**PROJECT: Bullawah Wind Farm | SSD-50505215**

**Re: Submission for Exhibition for State Significant Development Application | Bullawah Wind Farm (SSD- 50505215)**

Figure 3 Transport routes

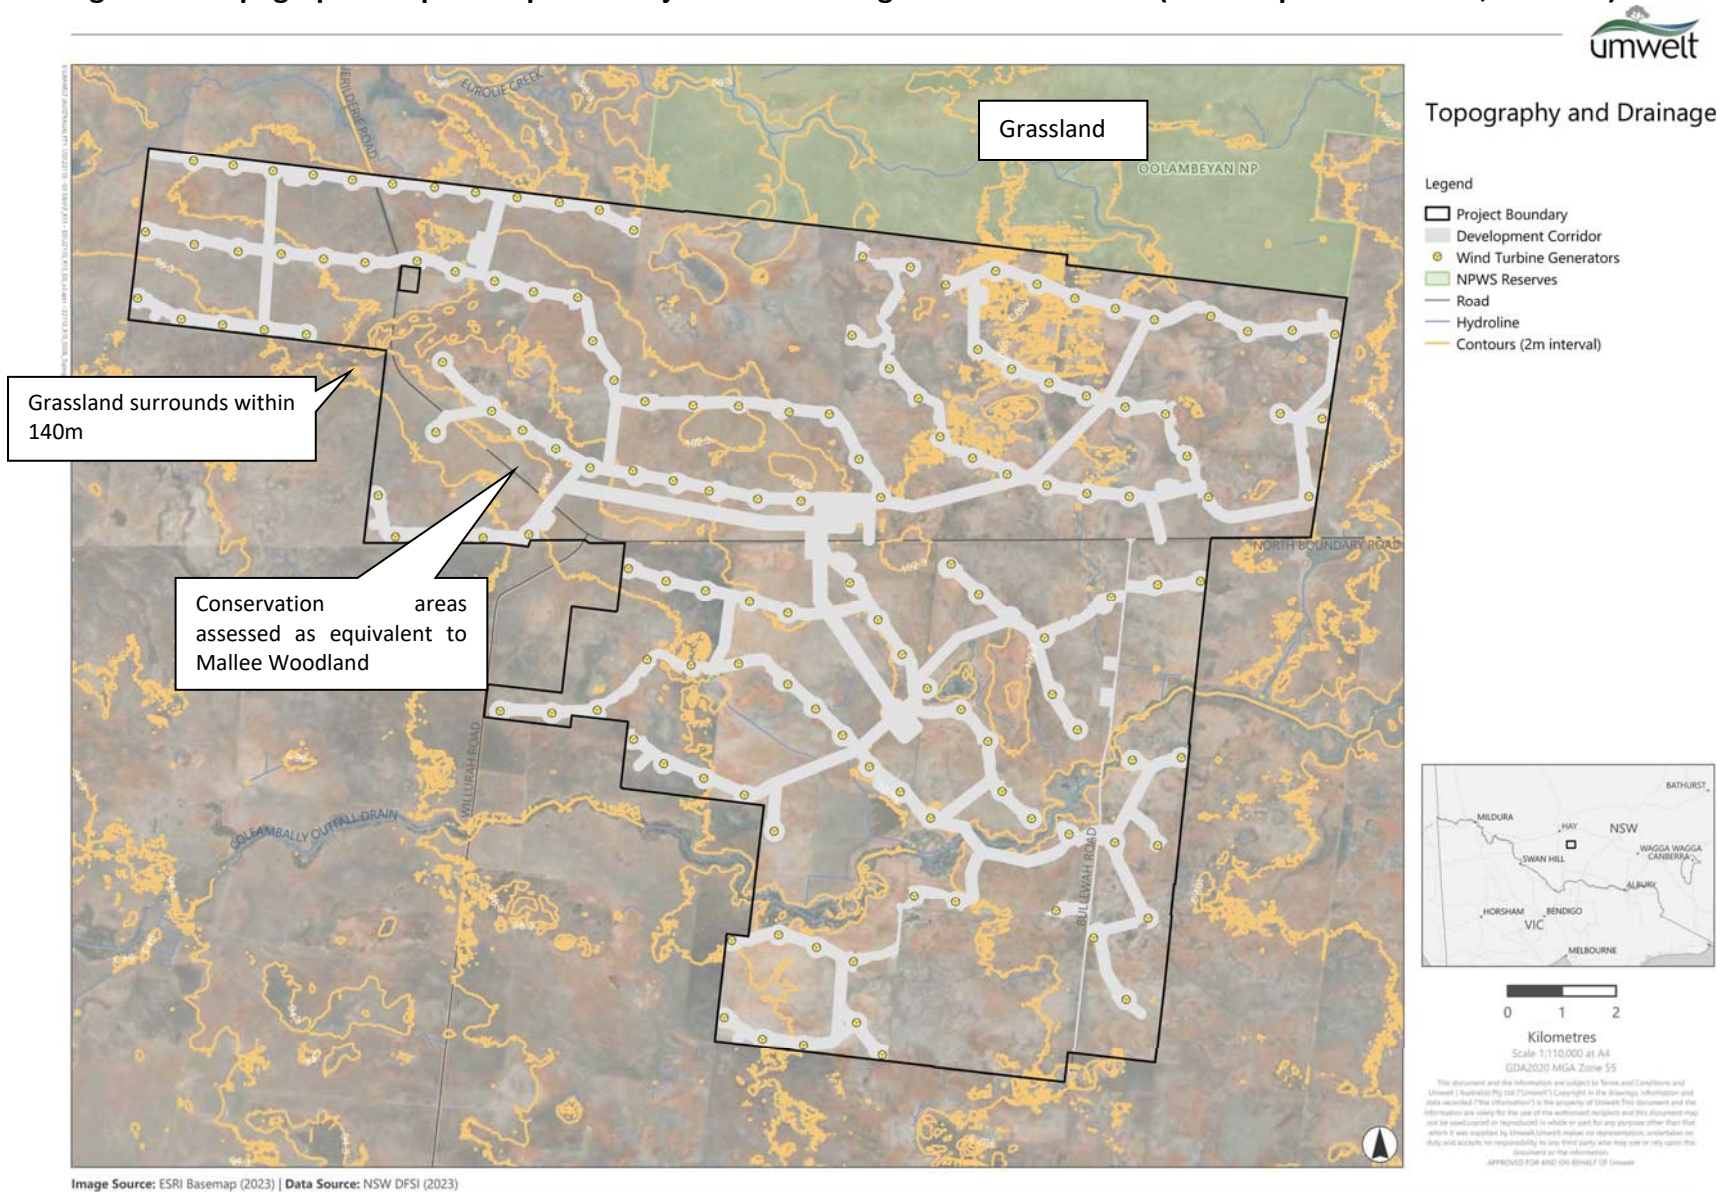
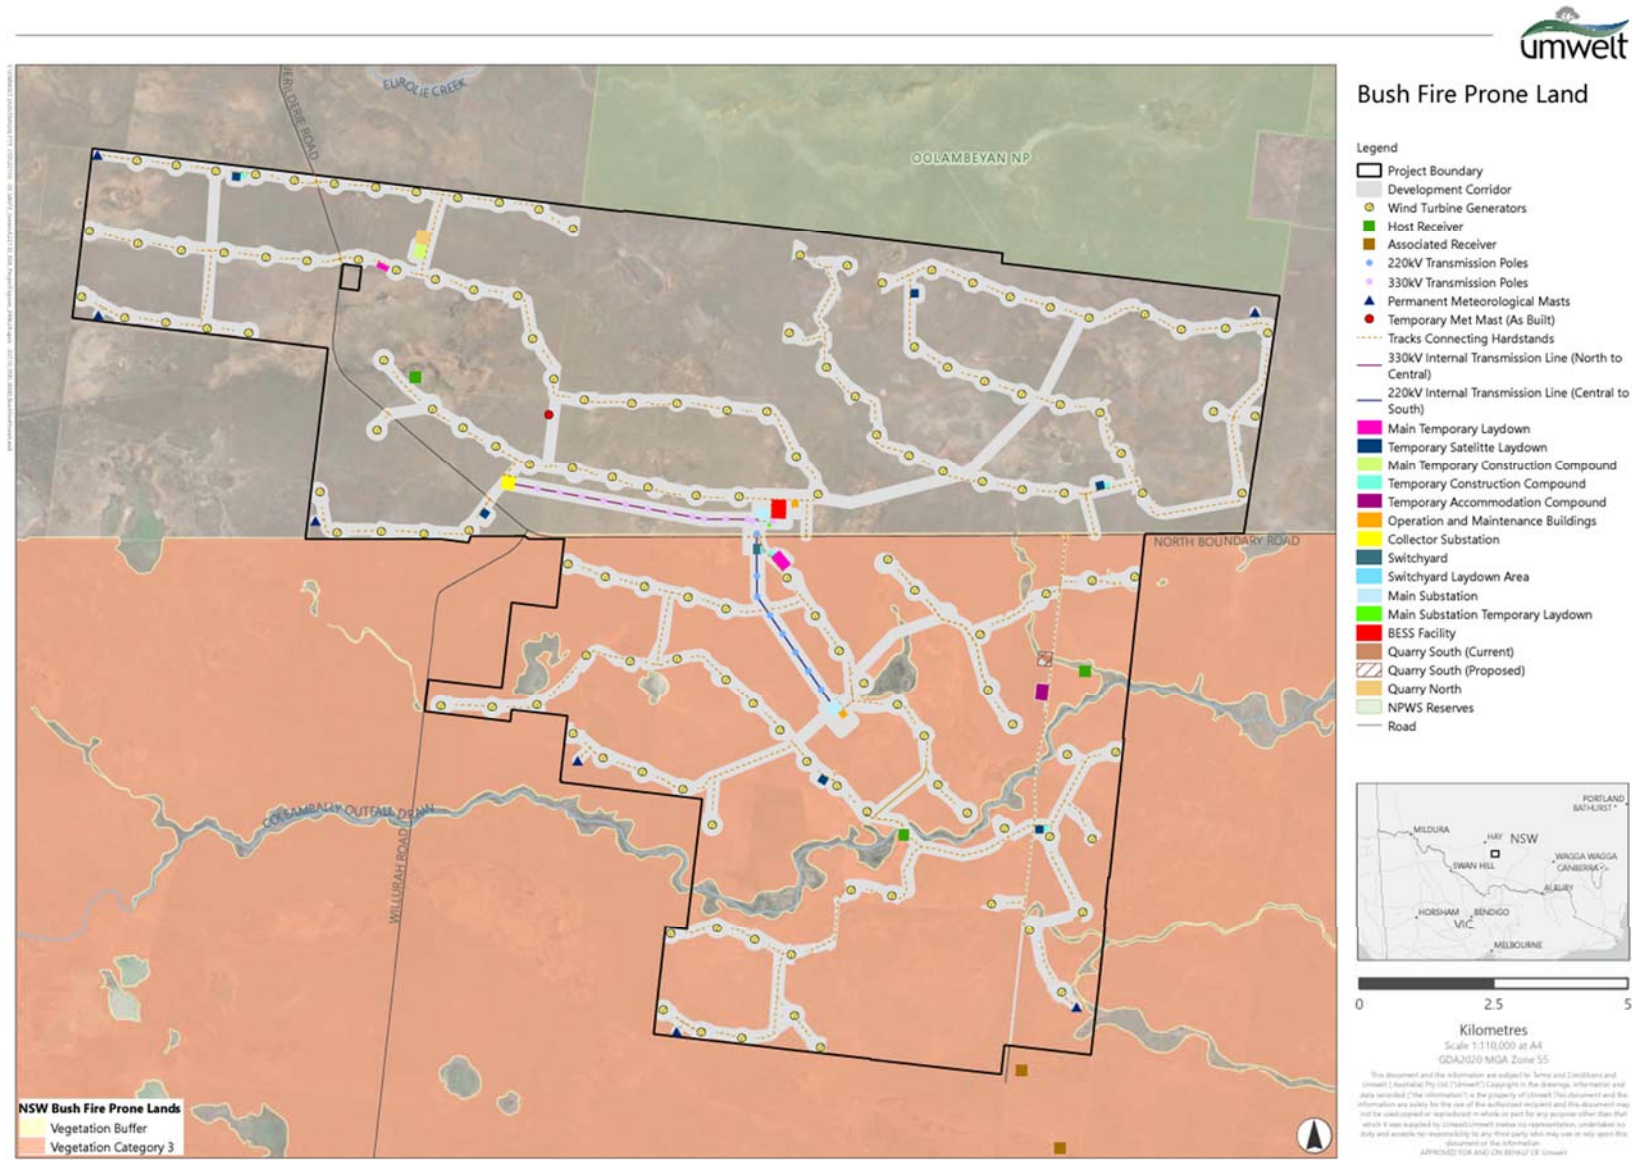
Bushfire risks associated with the construction and operation of the development are very generally covered in the EIS. Of specific concern is the Bushfire Prone Land areas consisting of large expanses of grassland and the remoteness of these areas. Adequate resources would be required to protect these areas and the properties of adjoining landowners in the event of fire outbreak. The availability of adequate resources, available fire personnel and response times due to travel distances, could be catastrophic in the event of a fire outbreak. A site-specific plan should be provided for consideration.

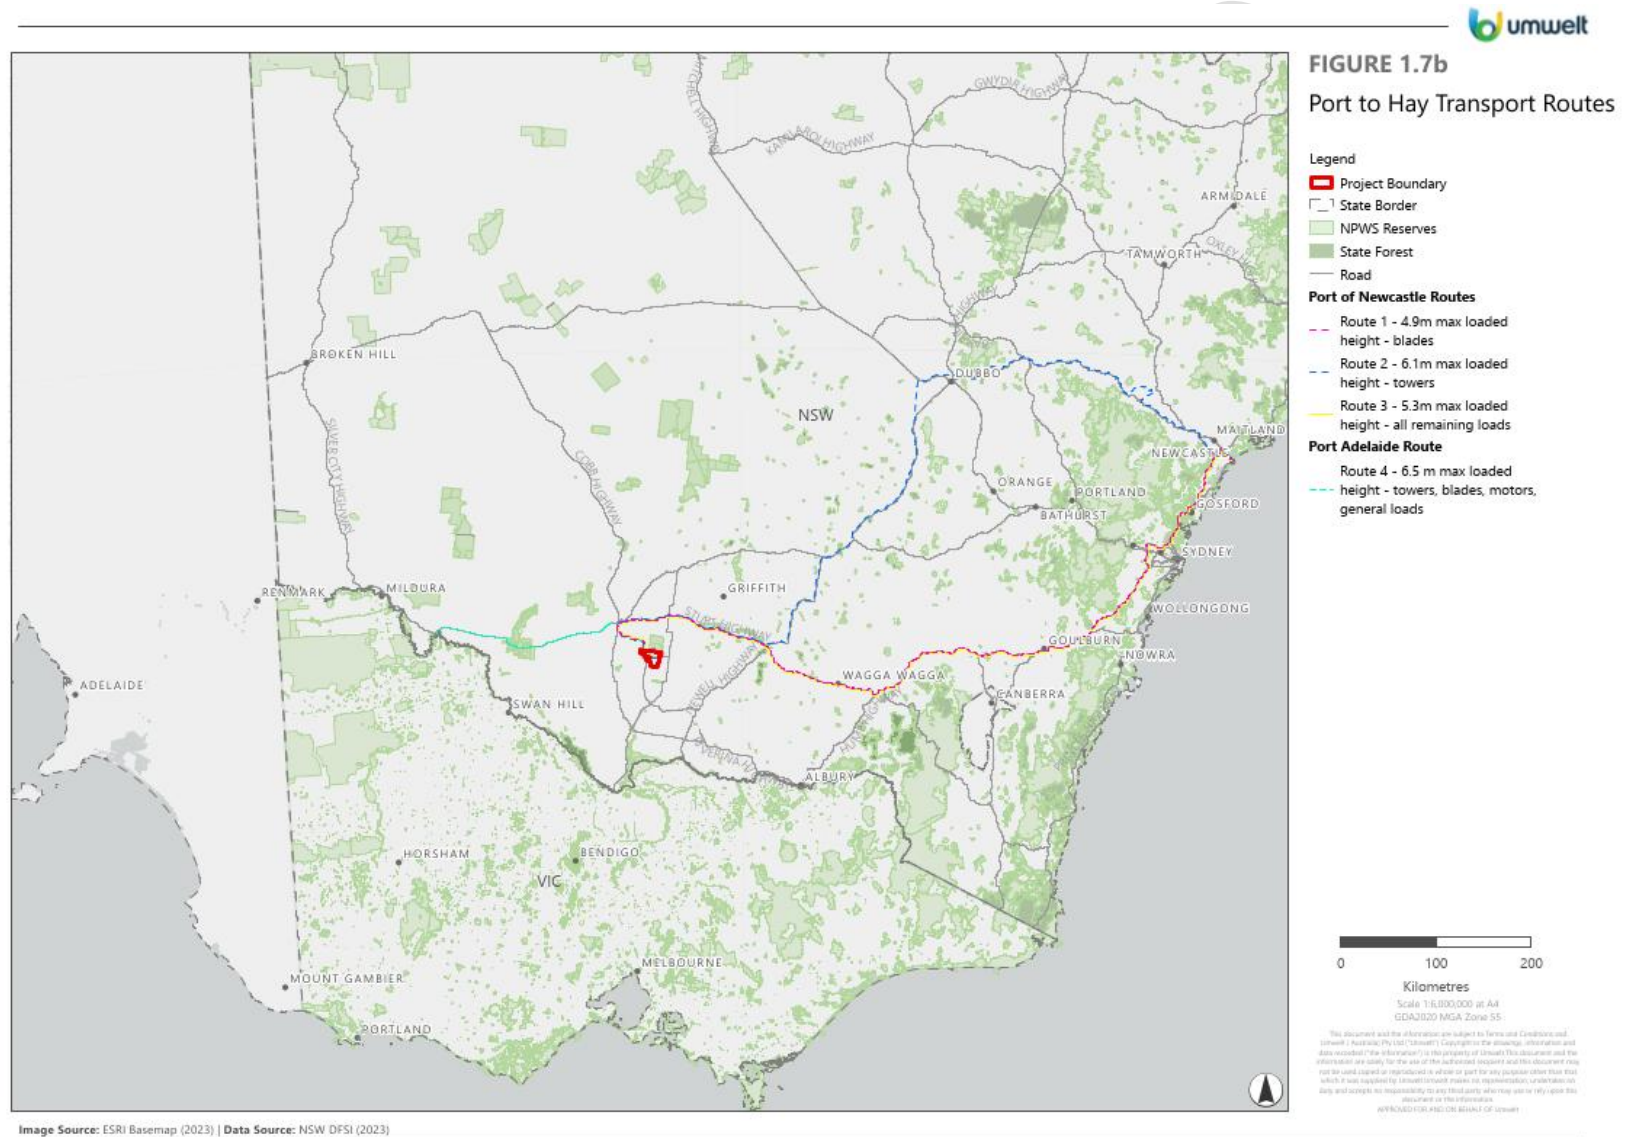
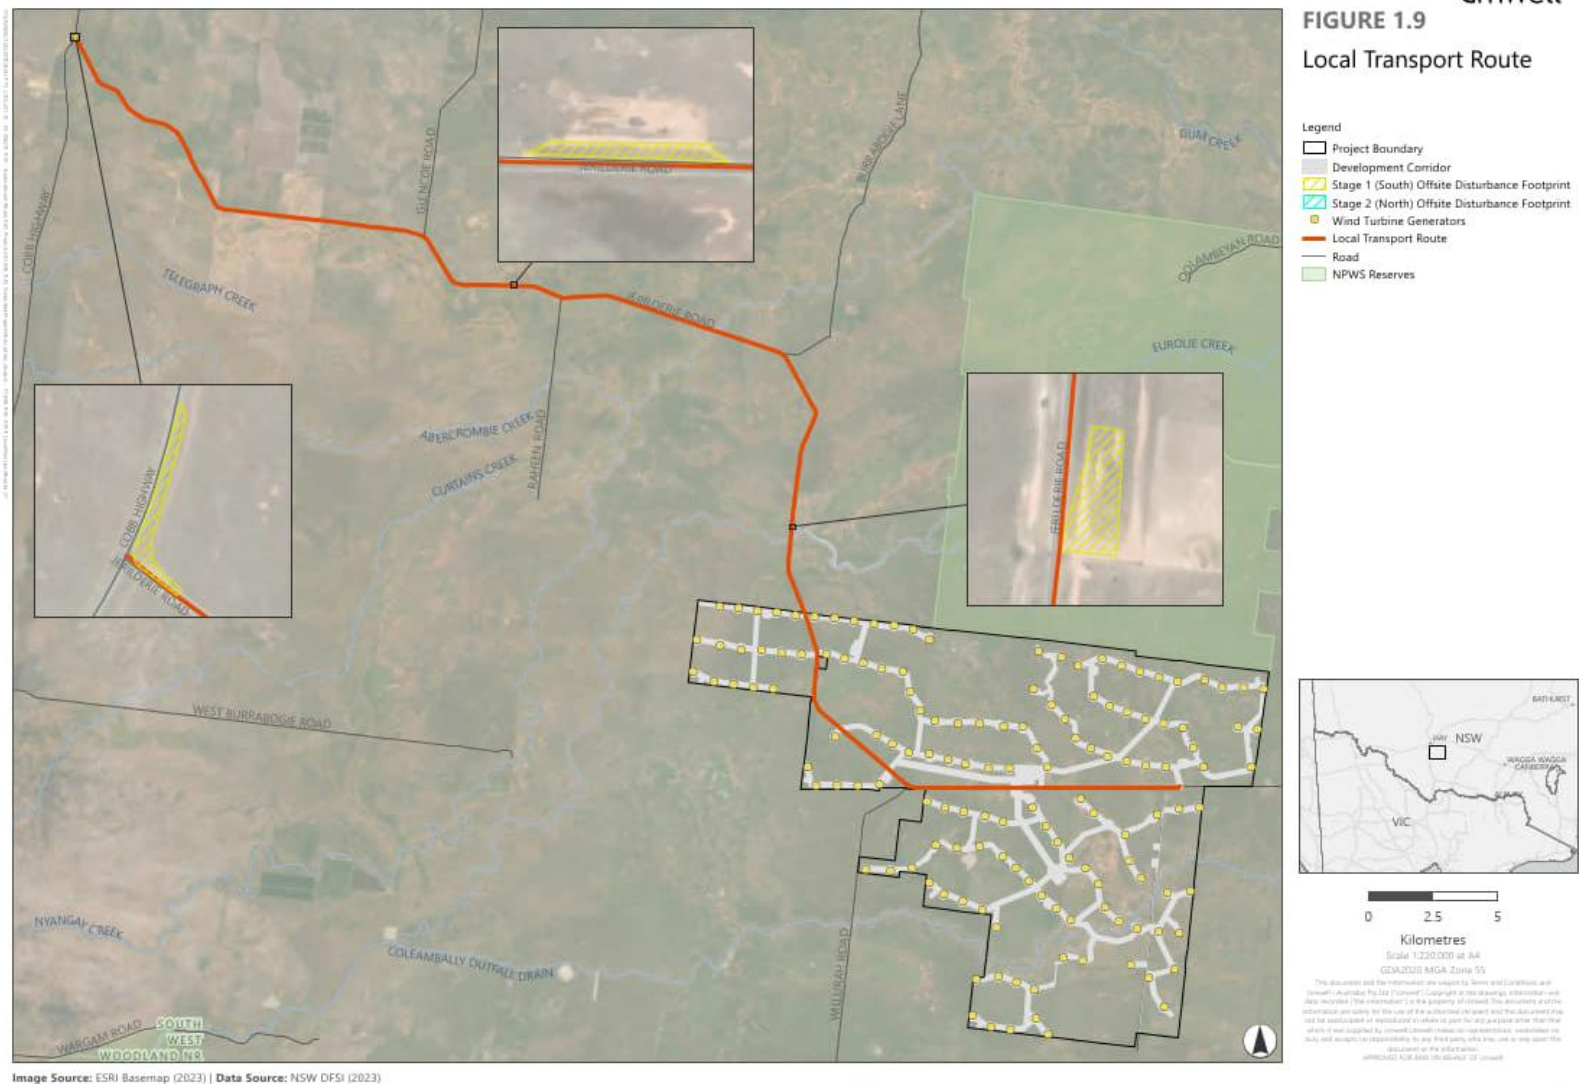
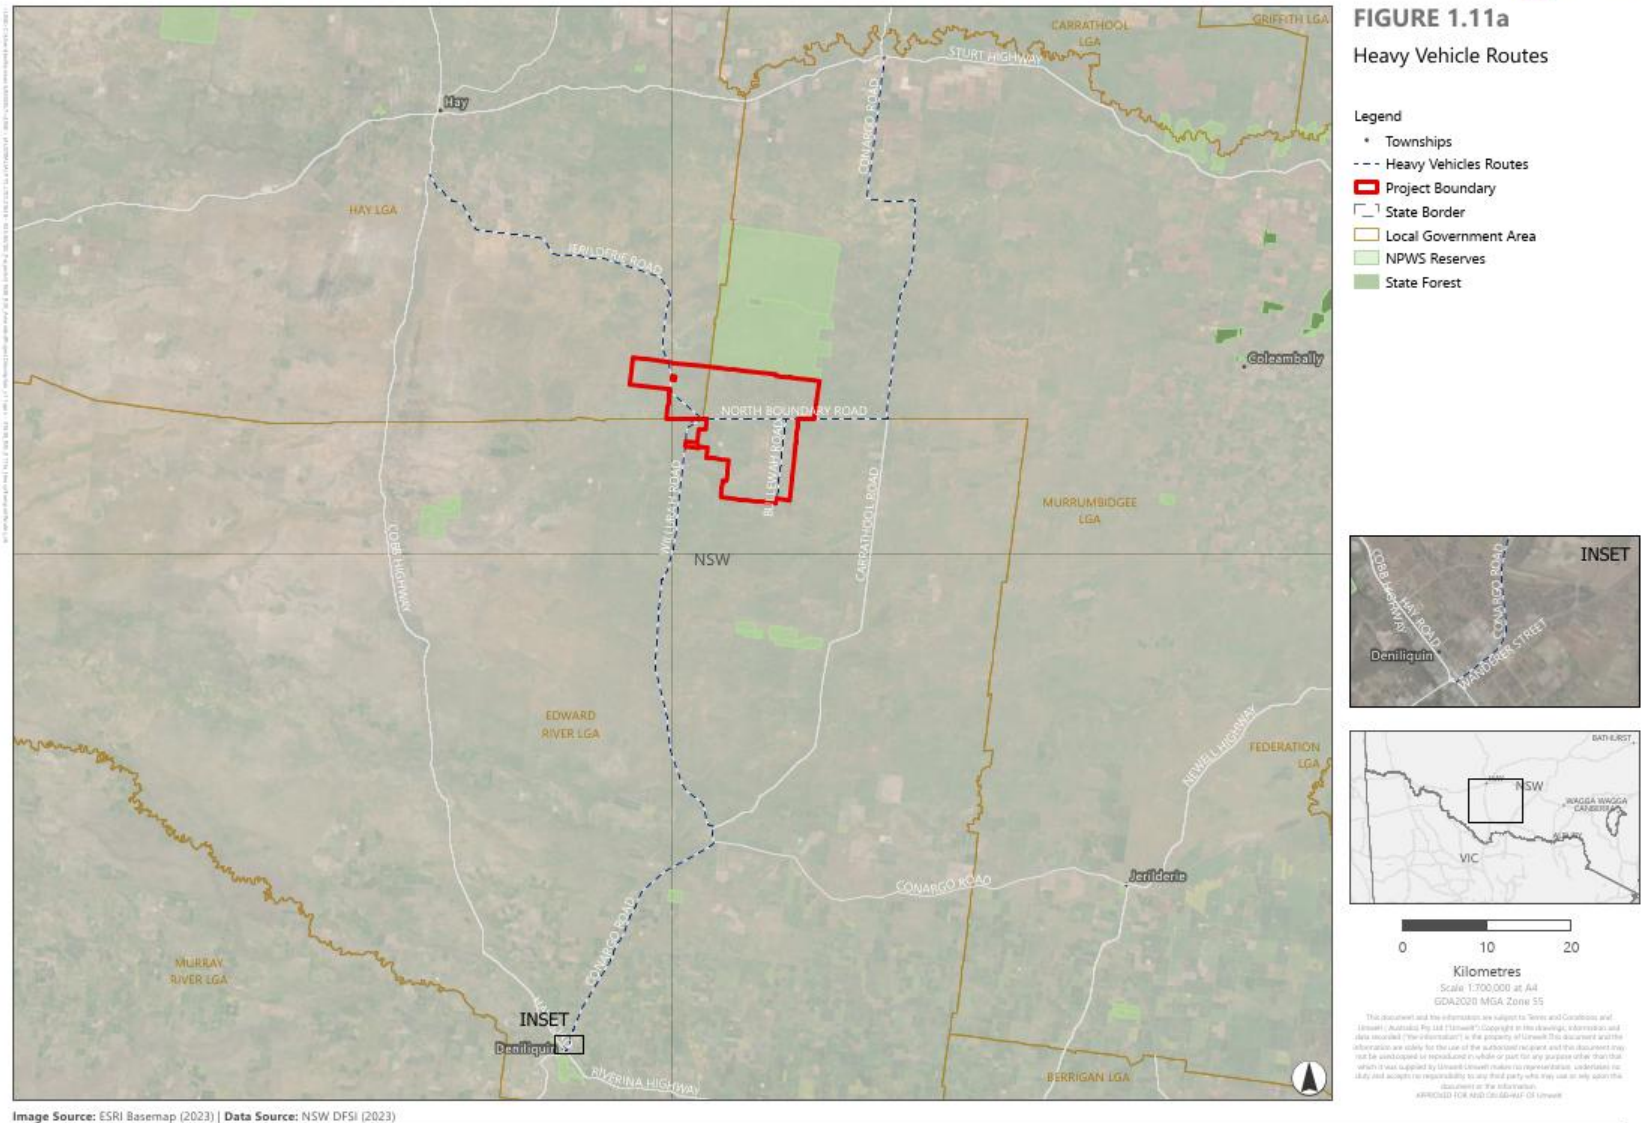
Specific detail on the source location of construction materials and proposed haulage routes , is important noting that this may impact on the local roads and local traffic movements through affected Local Government Areas (LGAs). Where impact is identified details of any proposed alteration to traffic movements, upgrade works and maintenance works agreements should be negotiated.
